MONUMENT FIRE DISTRICT
16055 Old Forest Point, Suite #102
Monument, CO 80132
(719) 484-0911
www.monumentfire.org
Proudly serving the Tri-Lakes Region

To: Development Review, El Paso County
From: Jonathan Bradley, Fire Marshal
Subject: Urban Landing PUDSP
Date: July 31, 2024

The Monument Fire District has reviewed the PUD development plan for Urban Landing. Based on our initial review of site access, water supply, and fire mitigation, we have the following comments.

URBAN LANDING
PRELIMINARY PLAN
FIRE TRUCK ACCESS EXHIBIT

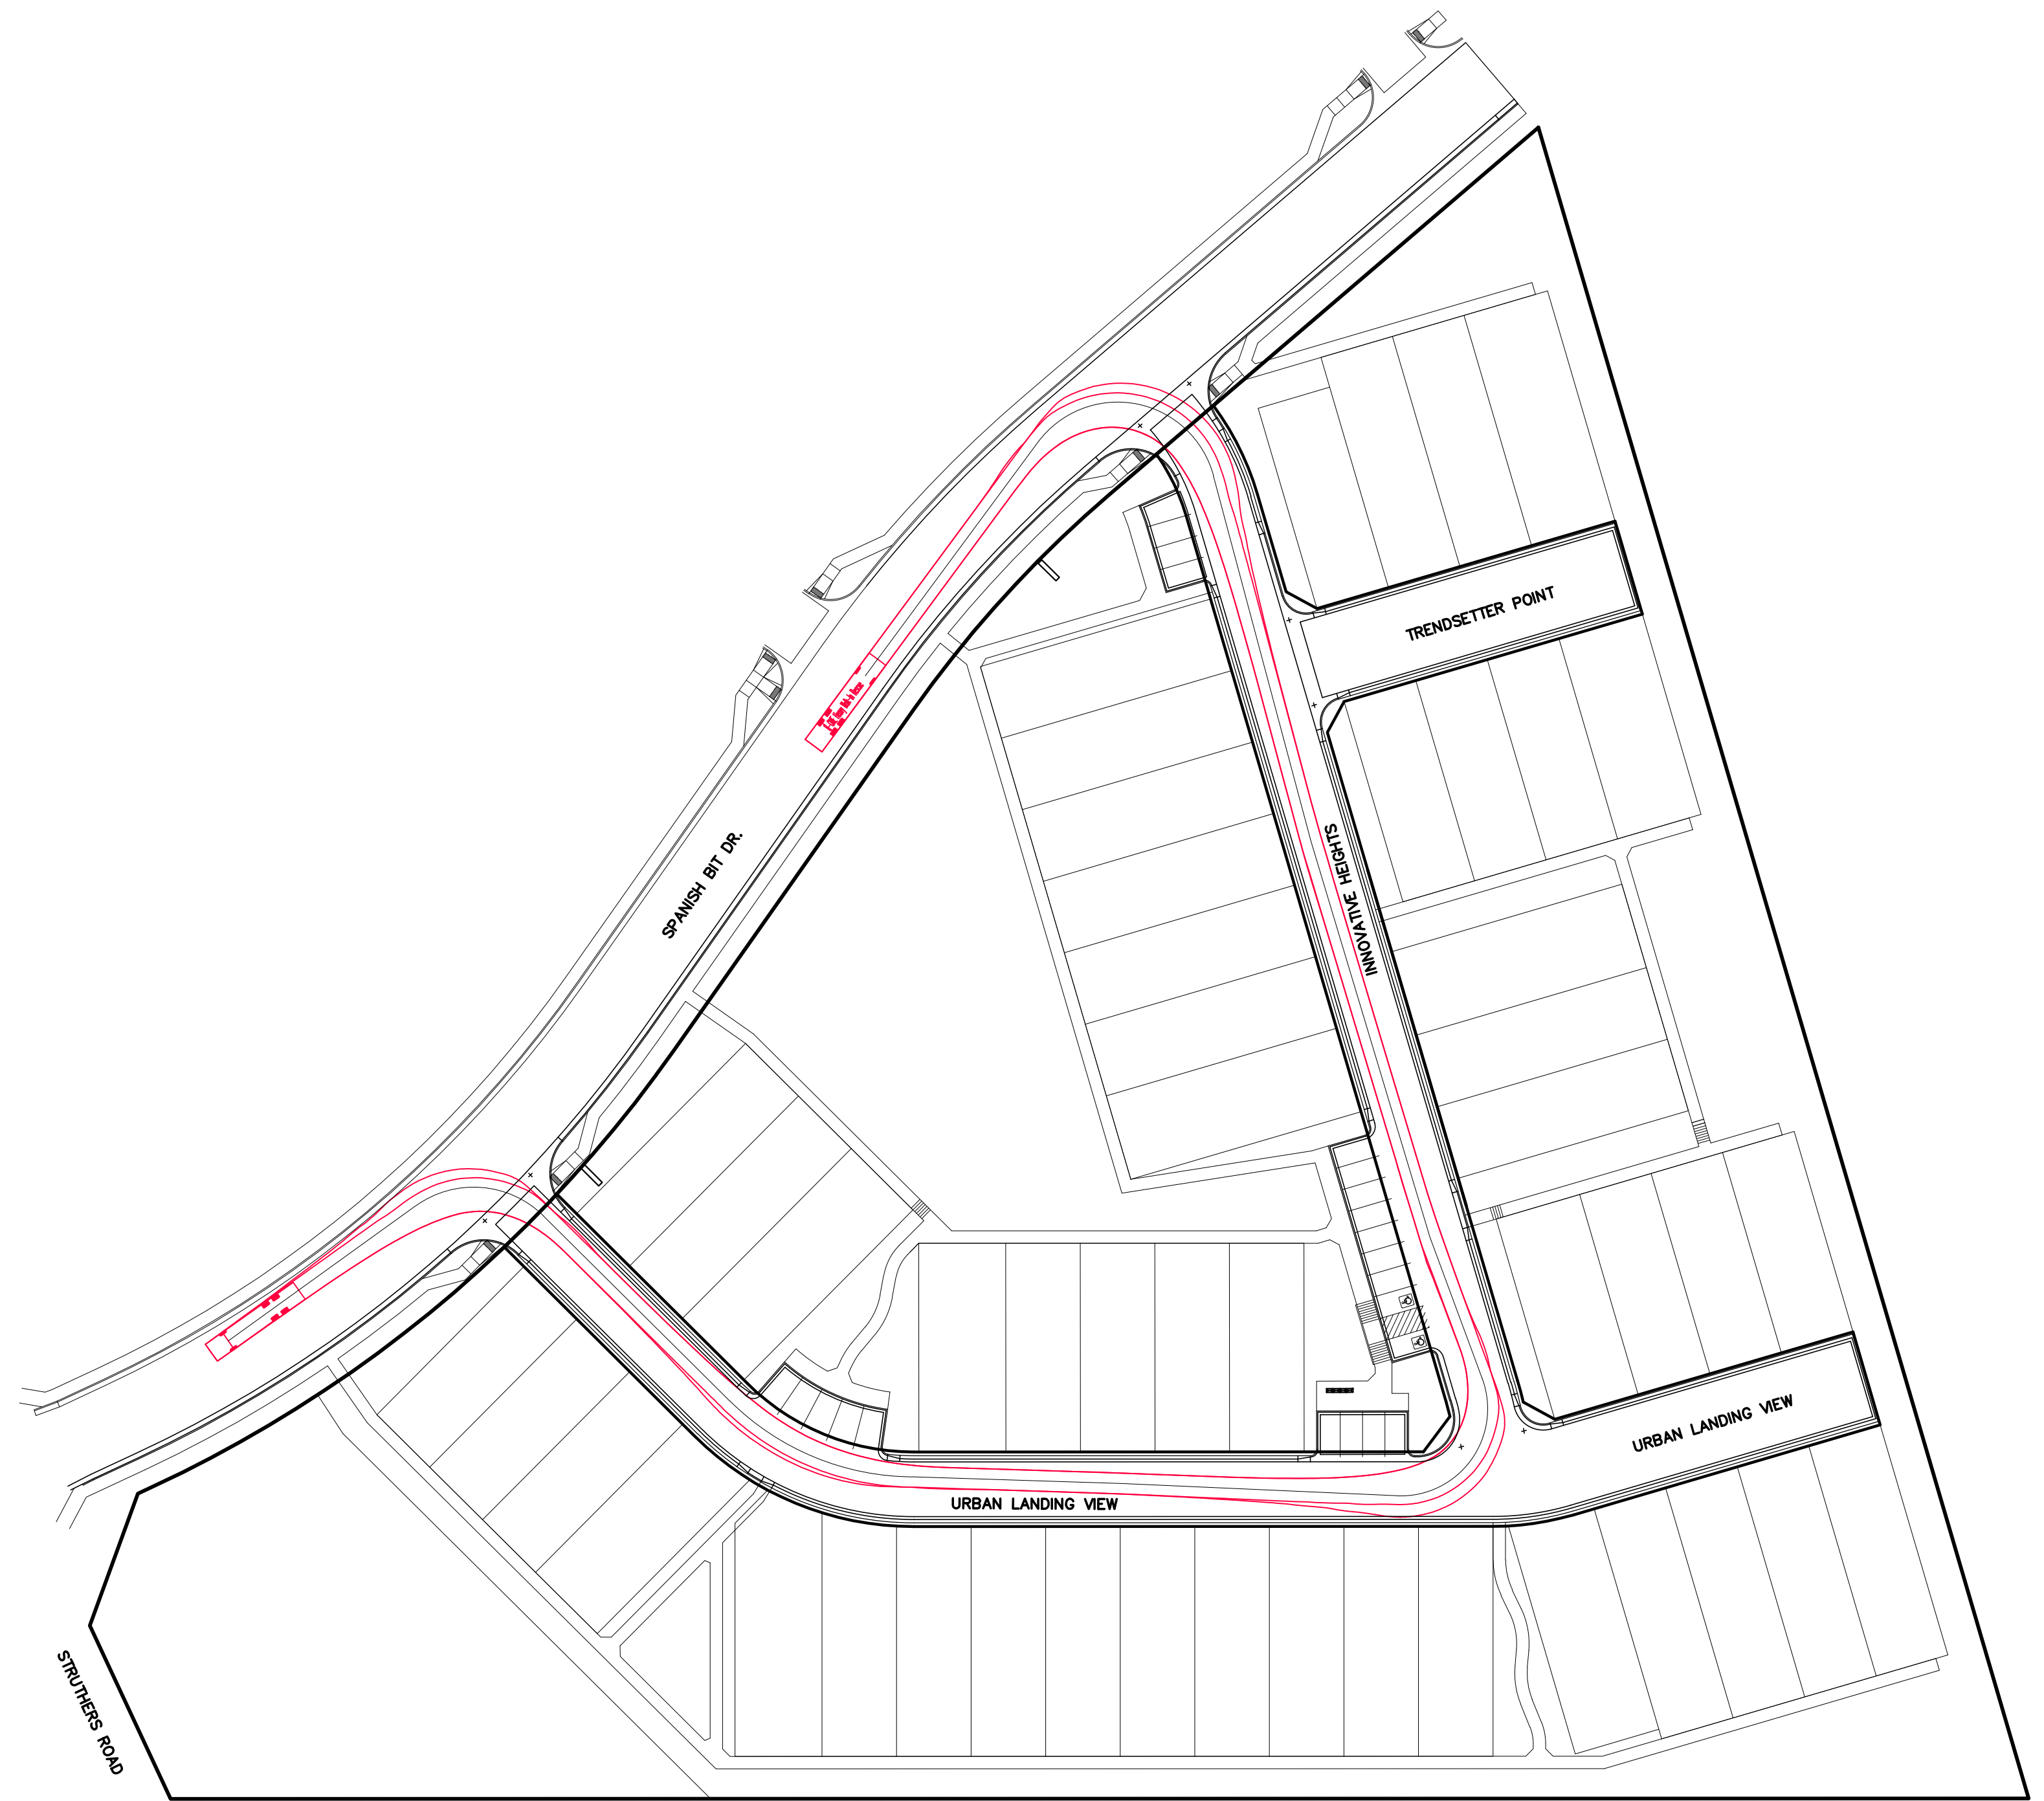
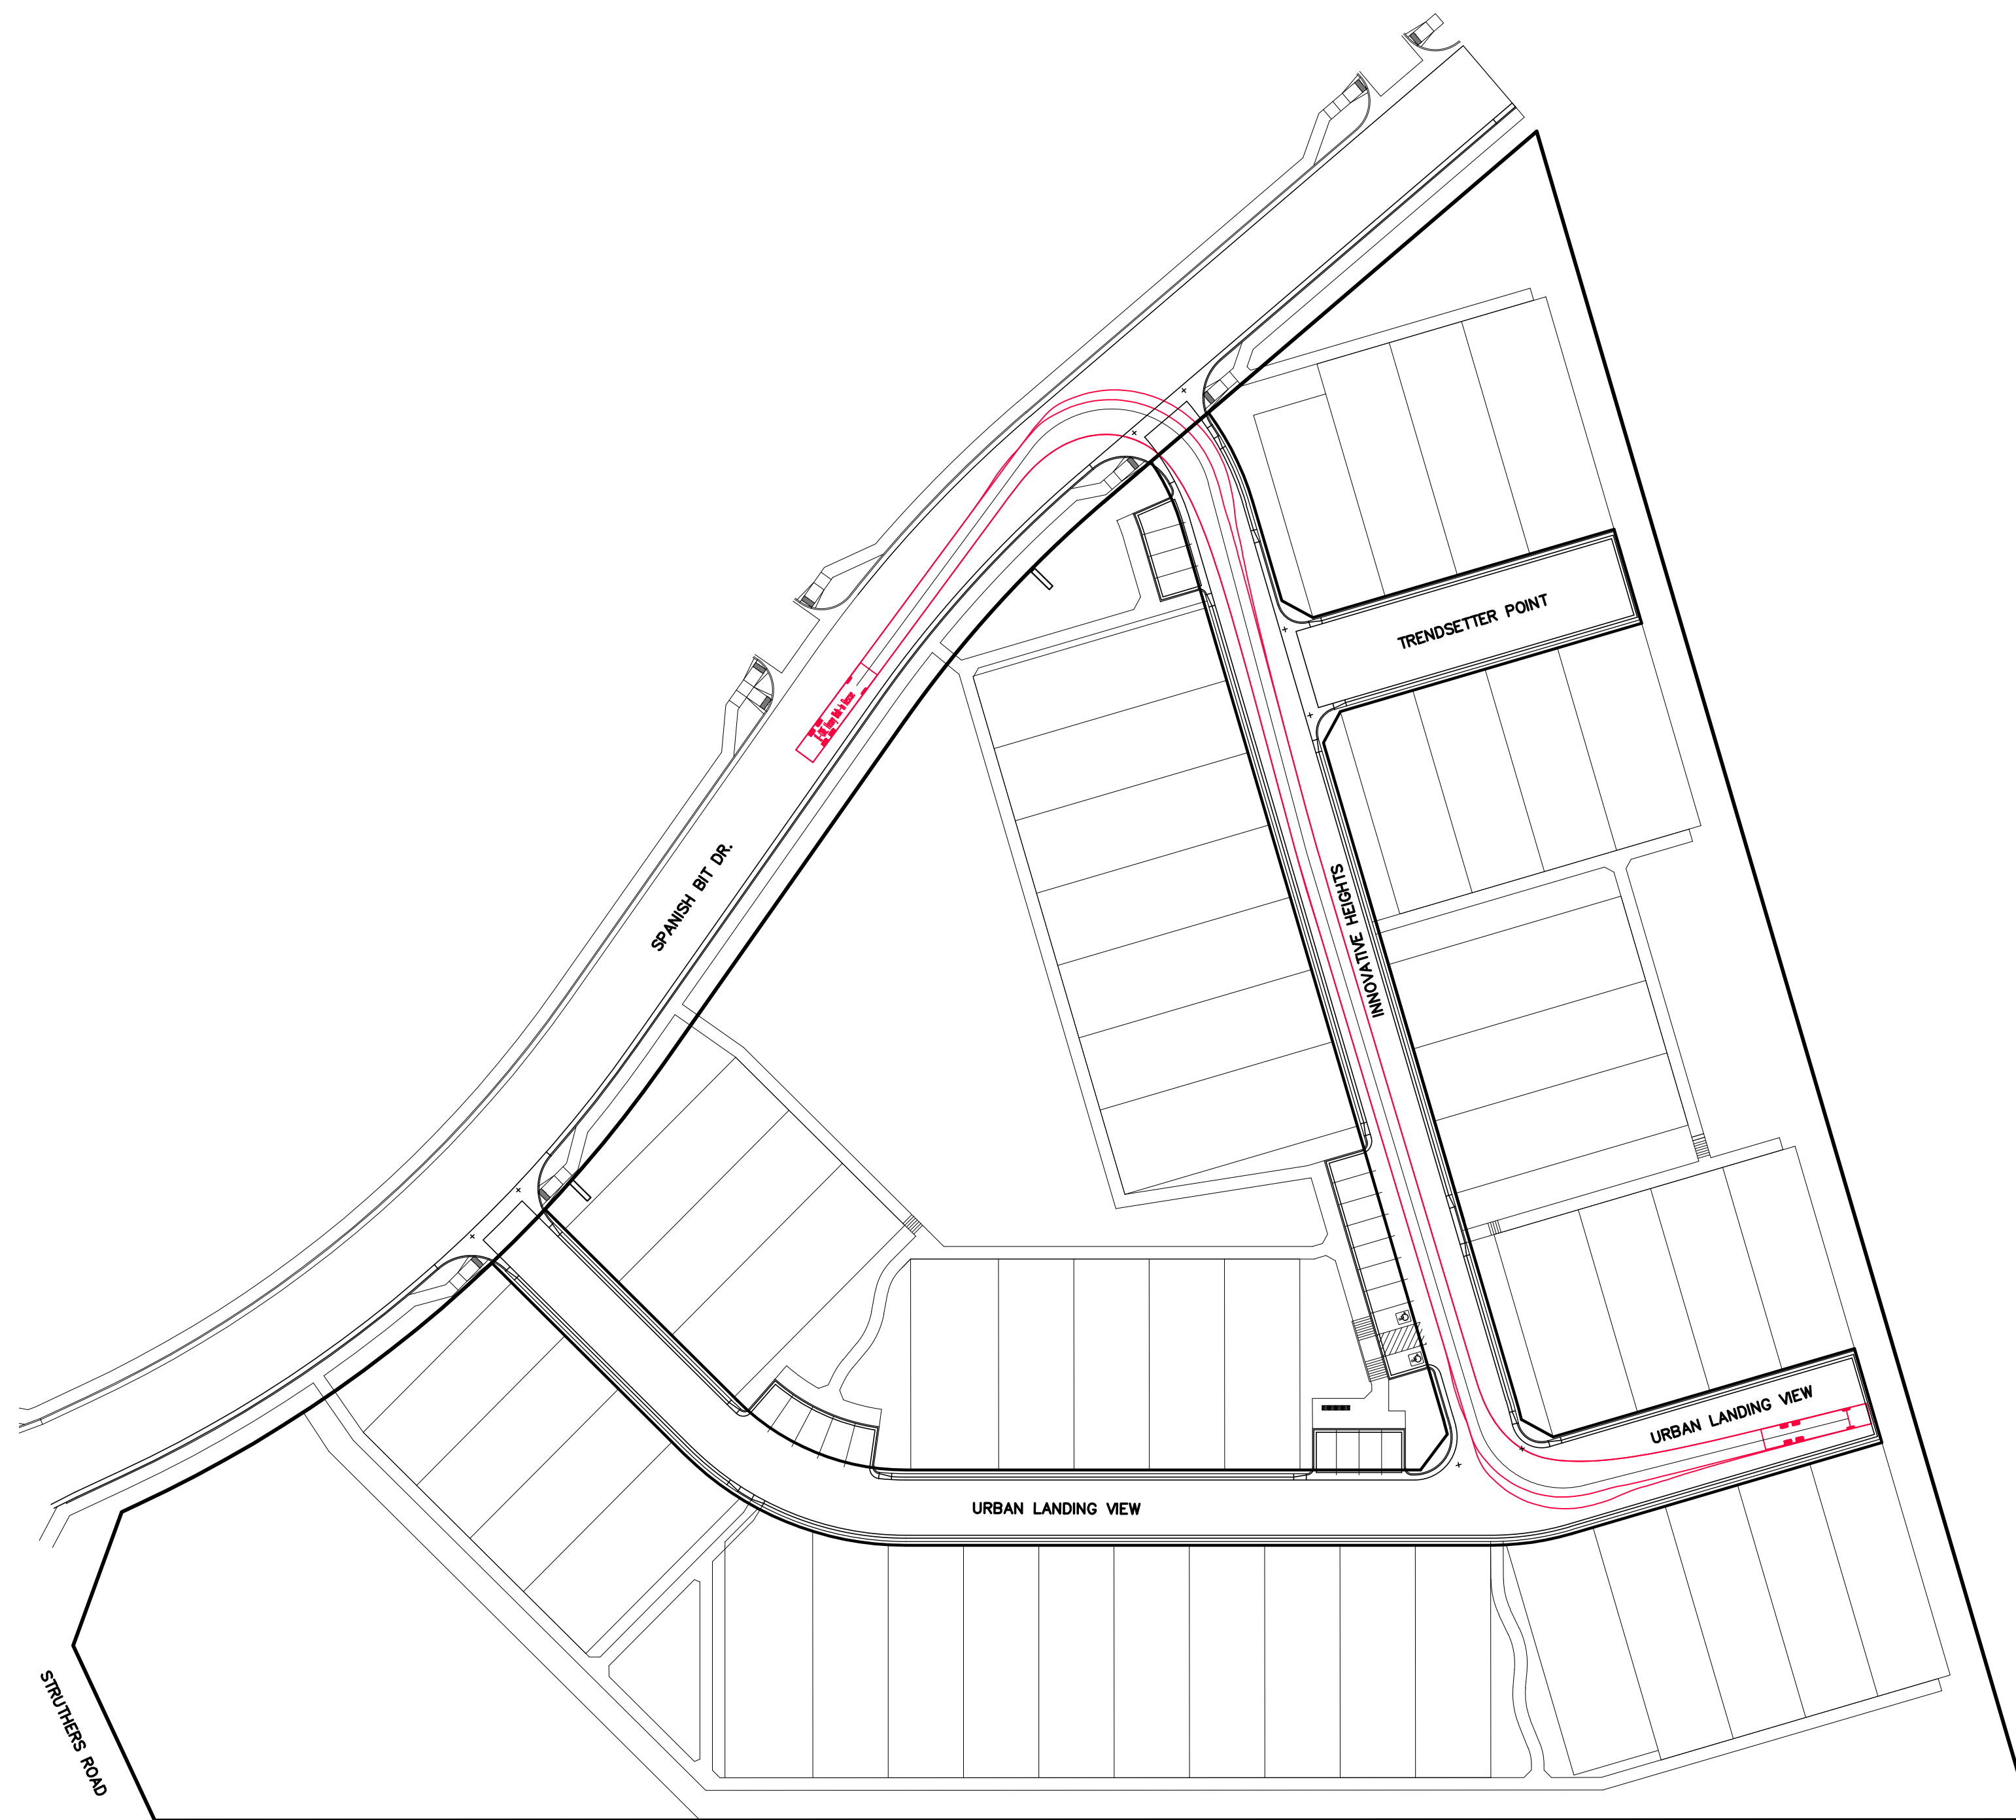
- FD prefers EPC Optional Type C curb and Gutter throughout the development (except designated parking areas) due to narrow roadways to allow large fire apparatus to mount the curb while turning or passing without damaging wheels and tires (see page 3 of 9 in PUD Development Plan).
- Evaluate turning radius for attached fire apparatus drawing and determine if proposed roadways will accommodate large vehicle operation.
